Subject: Re: FG/59/20/HH - Request for further information

This email is regarding the application proposed at 10 Highdown Way, Ferring.

Client: Mr. P Simpson
Site: 10 Hlghdown Way
 Ferring
 West Sussex
Description: North & South Elevations
Drawing No.: HD 20003
Scale: 1: 100 @ A3

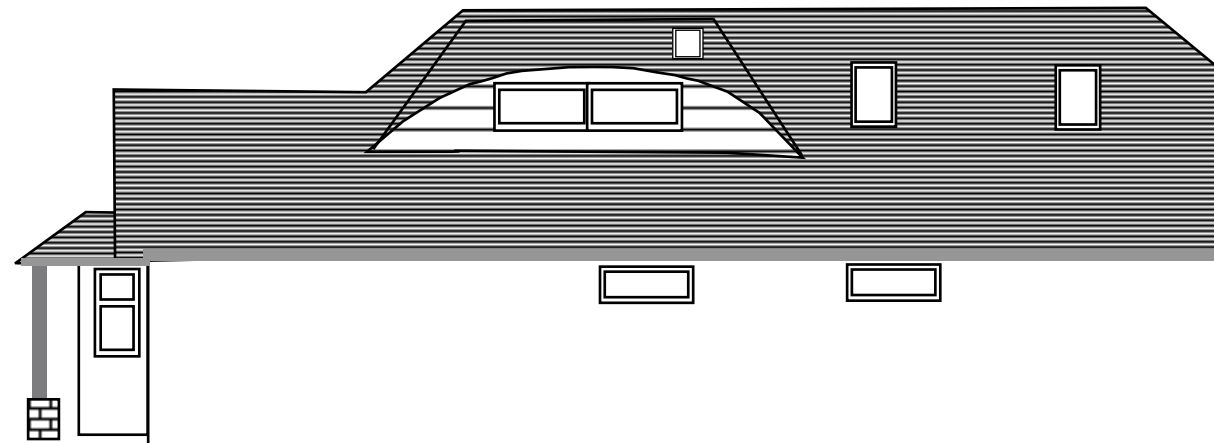
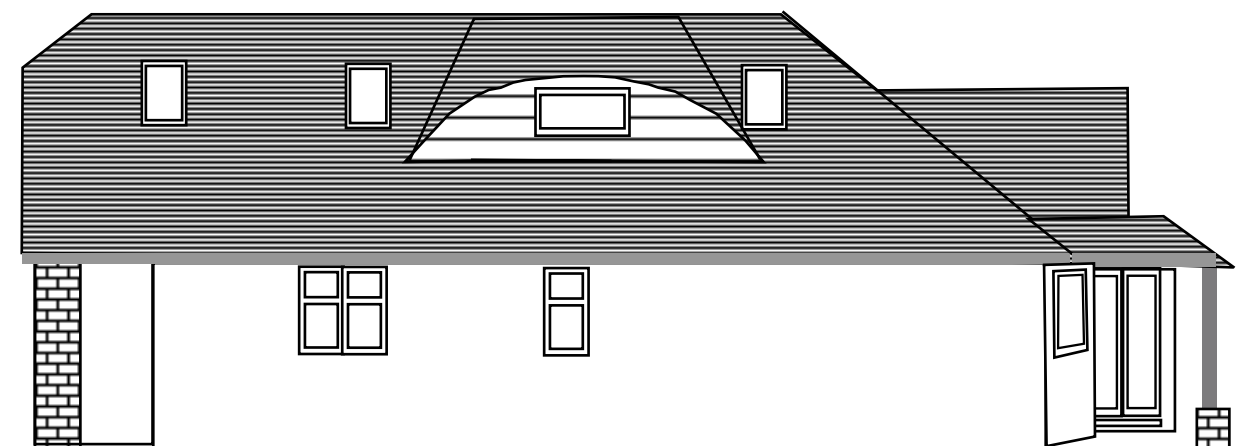
How high above the internal floor level are the proposed rooflights?

they should start at 1400 above floor level and finish at 1900
